**ACORNS
PROJECTS
LIMITED**

**Land at Barnsley Road, Grange Moor, Wakefield
Proposed Site Access Arrangements
Stage 1 Road Safety Audit**

**For Sanderson Associates Consulting Engineering
Prepared by Acorns Projects Limited
Safety Traffic Project Management & Highway Engineering Consultants**

JULY 2024

Client	PCS Property Solutions Ltd			
Project Title	Land at Grange Moor Wakefield			
Drawing Title	Proposed Works			
Scale	AS SHOWN	Drawn By	TOD	
Drawing Size	A1	Checked By	PJM	
Date	Jan 2023	Approved By	KS	
	Drawing Number		Rev	
	151716-001		C

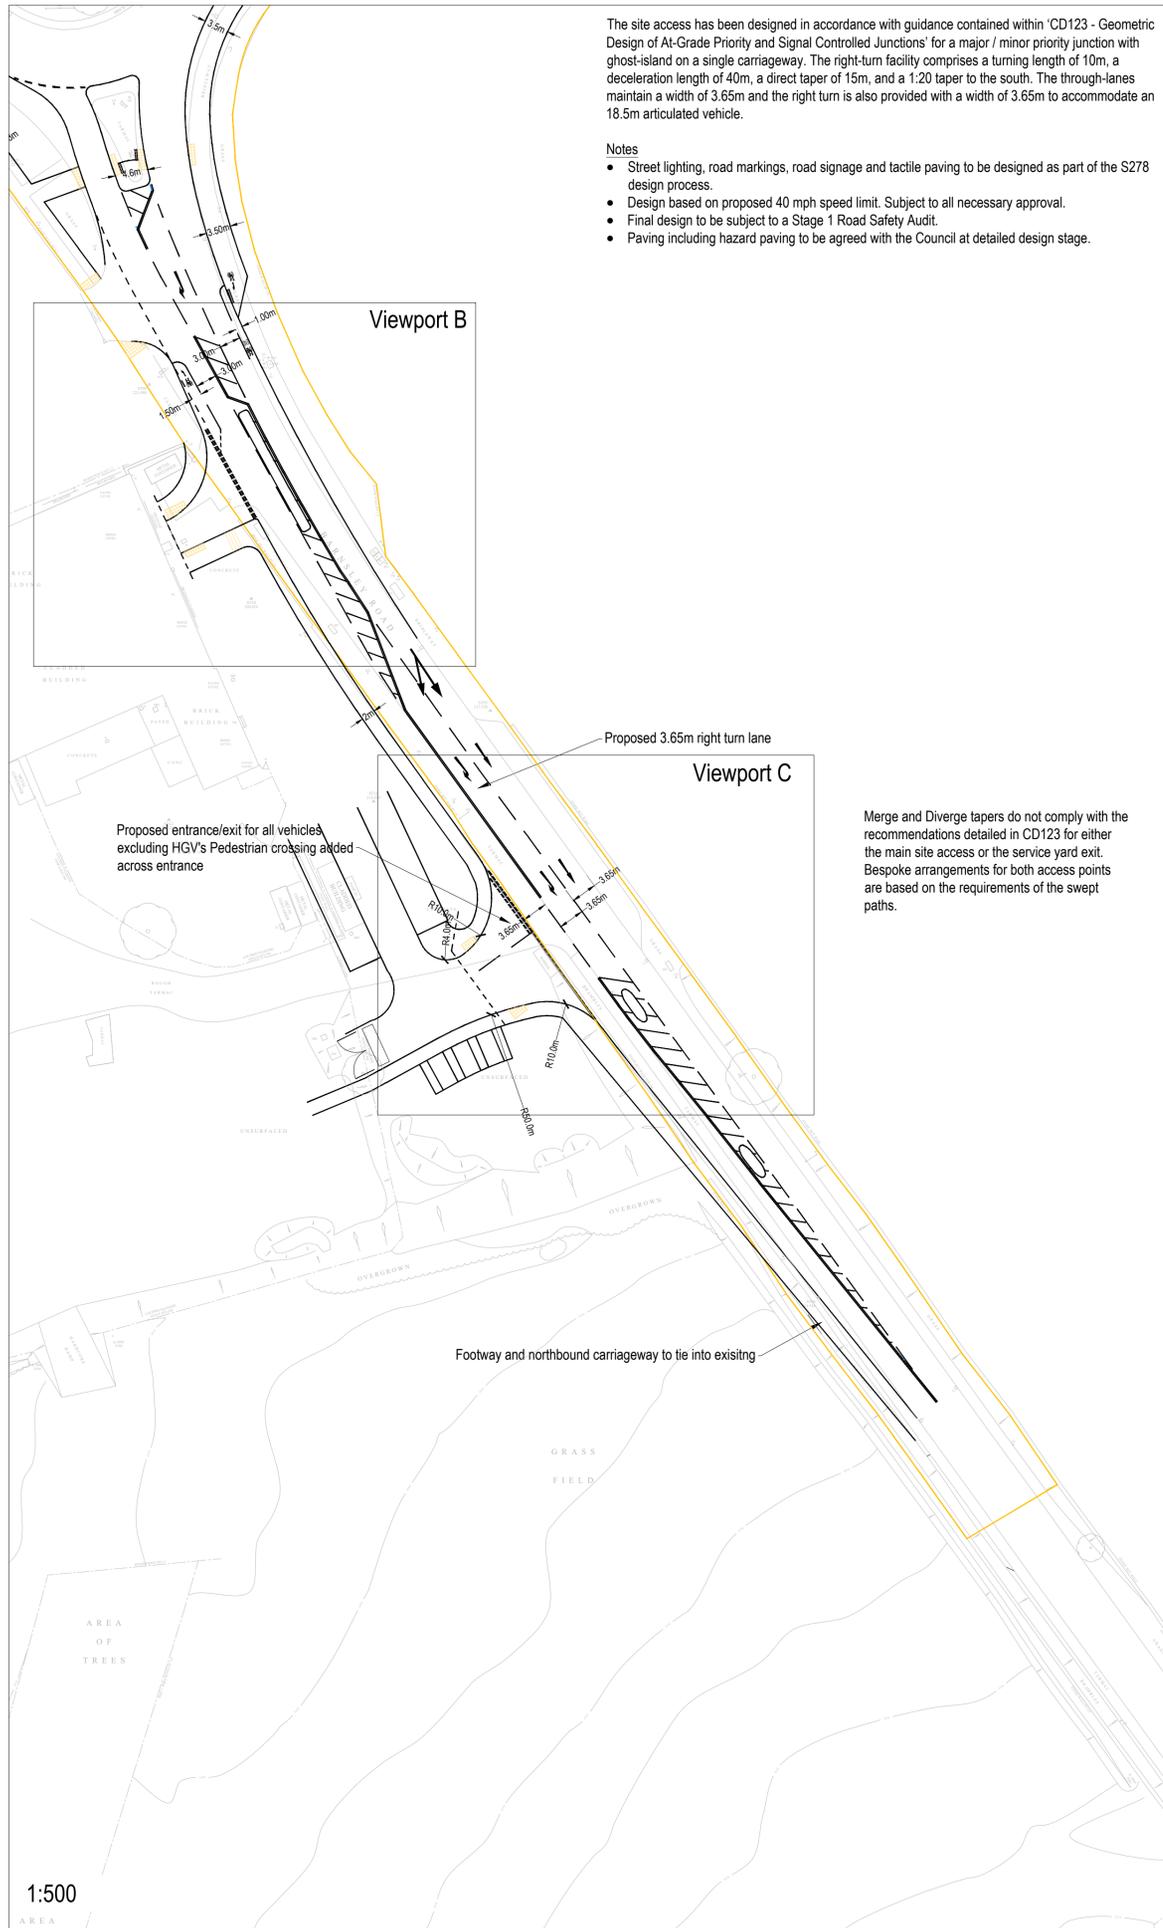
Location 4 - The southern priority T-junction for the proposed development site in Barnsley Road (Drawing Nos. 151716-001 Rev C & 151716-012 Rev A).

Summary - Potential restrictions to the proposed visibility splay for drivers emerging from the southern priority T-junction of the proposed development site could result in a potential increased risk of side impact vehicular collisions occurring, whereby vehicle occupants could sustain personal injury.

Detail - The scheme drawing indicates that an existing vehicular access will be modified in order to create a new priority T-junction, which will become the new southern access for the proposed development site in Barnsley Road. In order to accommodate the ghosted right turn facility within the centre of Barnsley Road, carriageway widening will be required. In effect, this will result in the proposed visibility splay of 4.5 x 120 metres being set back significantly when compared to the situation for the existing vehicular access.

The site visit has established the presence of an existing dense hedgerow and stone wall, both of which could impact upon the proposed junction visibility scheme for drivers seeking to emerge from the proposed southern access/egress junction.

Concern arises that any potential restrictions to the proposed visibility splay of 4.5 x 120 metre visibility splay could lead to a potential increased risk of side impact vehicular collisions occurring, between drivers emerging from the proposed development site and north west bound Barnsley Road vehicular traffic, whereby vehicle occupants could sustain personal injury.

It is Recommended that that the visibility splays should be kept clear of any impediments such as the existing identified site features, in order to reduce or mitigate the above described potential collision scenario.

Location 8 - The proposed shared use footway/cycleway at the northern egress junction (Drawing No. 151716-001 Rev C).

Summary - An existing low level wall could restrict the future width of the proposed shared use footway/cycleway, which could lead to a potential increased risk of pedestrian and pedal cyclist collisions occurring with the existing feature, as well as a potential increased risk of pedal cyclist and pedestrian collisions occurring, whereby pedestrians and pedal cyclists could sustain personal injury.

Detail - The scheme drawing indicates the provision of a shared use footway/cycleway on the northern side of the northern egress junction. The site visit has established the presence of an existing low level wall on the northern side of the proposed egress junction, which could impact the future width of the proposed shared use footway/cycleway at this location.

Concern arises that should the existing low level wall remain within the proposed shared use footway/cycleway, this situation could lead to a potential increased risk of pedal cyclist and pedestrian collisions occurring with the existing feature whereby pedestrians and pedal cyclists could sustain personal injury.

In addition, concern arises that retention of the existing low level wall will restrict the future available width of the proposed shared use footway/cycleway, which could lead to a potential increased risk of pedestrian and pedal cyclist collisions occurring, whereby pedestrians and pedal cyclists could sustain personal injury.

It is Recommended that the existing low level wall should be completely removed when the proposed shared use footway/cycleway is constructed, thus optimising the future available width for pedestrian and pedal cyclist use.

Location 1 - The proposed right turn facility from Barnsley Road into the Blacksmith Arms car park (Drawing Nos. 151716-001 Rev C & 151716-007 Rev C).

Summary - Swept path requirements of larger delivery vehicles waiting within the right turn facility leading to the Blacksmiths Arms public house car park could lead to a potential increased risk of nose to tail shunt type vehicular collisions occurring, whereby vehicle occupants could sustain personal injury.

Detail: The scheme drawings indicate the provision of a right turn facility on Barnsley Road for drivers turning right into the Blacksmiths Arms public house car park area. Whilst a vehicle is not shown to be stationary within the right turn facility leading to the public house car park area, it is not unreasonable to suggest that vehicles, particularly larger delivery vehicles waiting to turn right, may encroach into the south east bound lane of the Barnsley Road carriageway.

Concern arises that the potential swept path requirements of larger vehicles encroaching into the south east bound carriageway of Barnsley Road when waiting to turn right into the public house vehicular access, could lead to a potential increased risk of nose to tail shunt type vehicular collisions occurring, whereby vehicle occupants could sustain personal injury.

It is Recommended that swept path analysis exercises should be undertaken, particularly for larger delivery vehicles waiting in the right turn facility.

Should the swept path analysis exercises demonstrate that stationary larger delivery vehicles encroach into the south east bound carriageway when waiting to turn right into the public house car park, it is further Recommended that the right turn facility should be modified, in order to reduce or mitigate the above described potential collision scenario.
